CITY OF ALBUQUERQUE

March 2, 2015

**Re: Heritage Marketplace
Engineer's Stamp Date 2-20-15 (H09D024)**

Based upon the information provided in your submittal received 2-20-15, the above referenced report cannot be approved for Site Plan for Building Permit action by the DRB until the following comments are addressed:

GRADING AND DRAINAGE PLAN

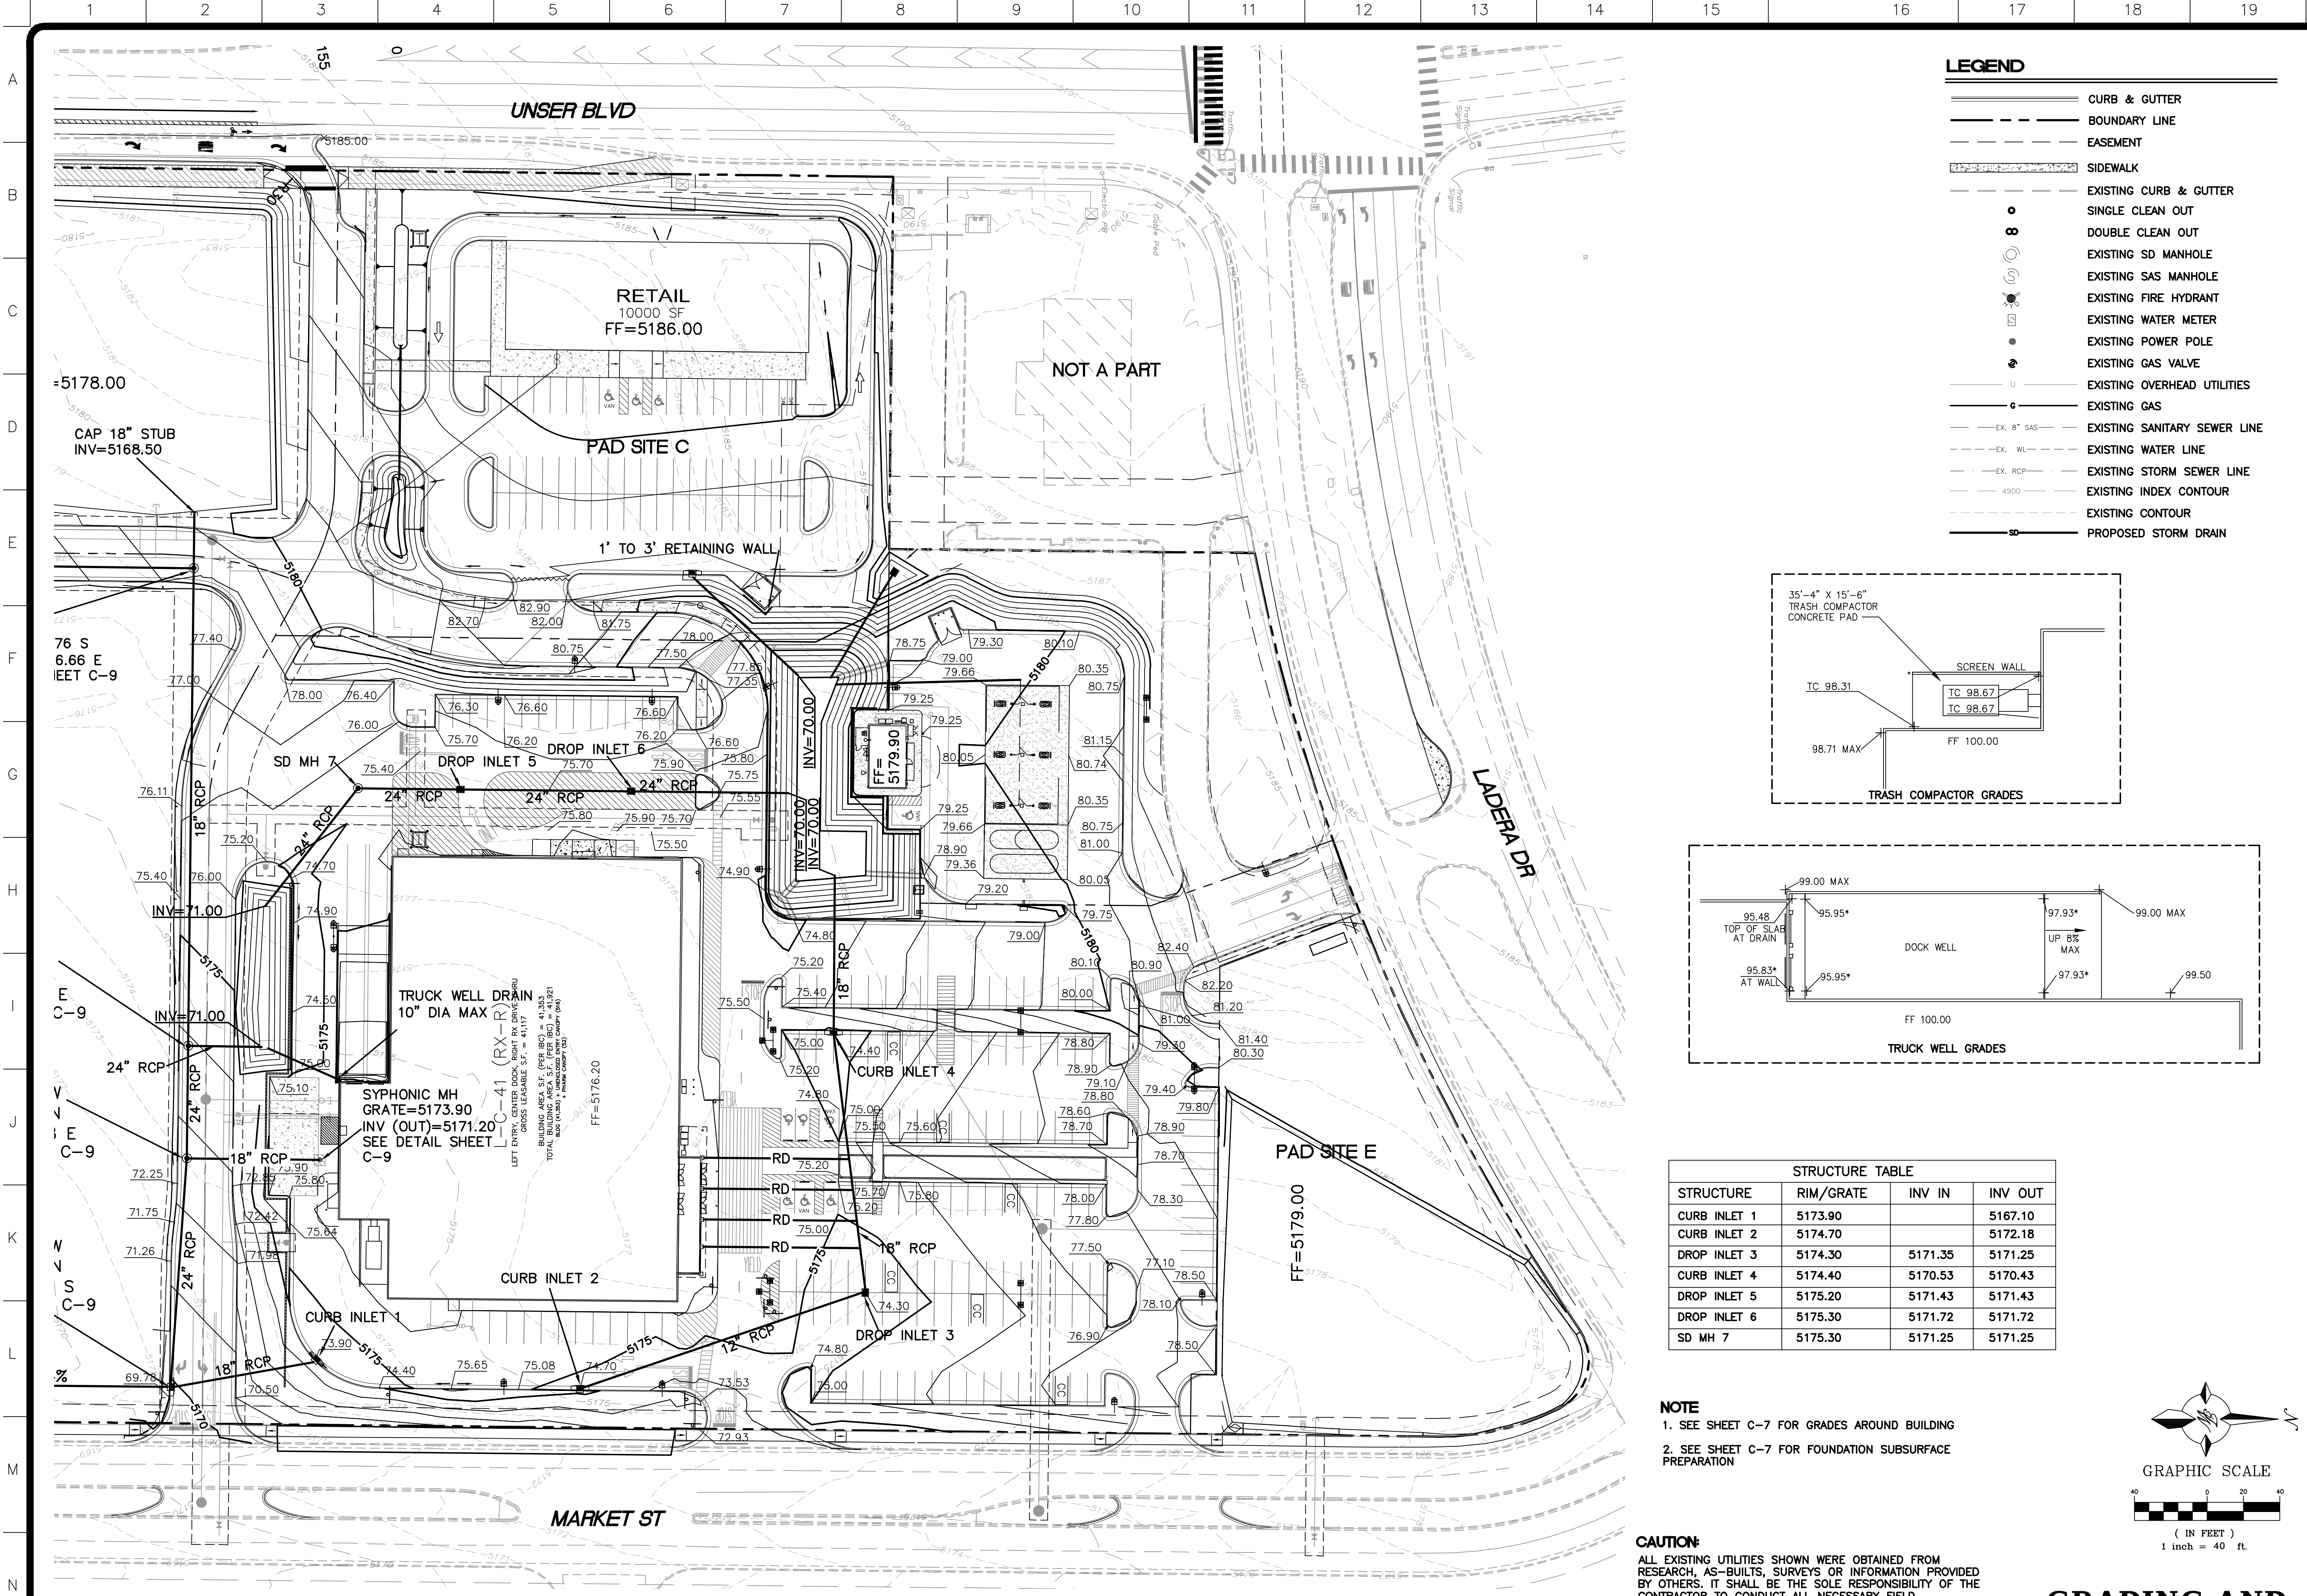
3. This plan proposes a fueling station. Runoff from the pump area is to be treated by an oil/water separator prior to leaving the area.
 4. The Conceptual Grading Plan shows Basin A2 as two basins. Show the basin divide and account for it in the report. This area could drain to Pond 2 and should not propose retention for flood control purposes.
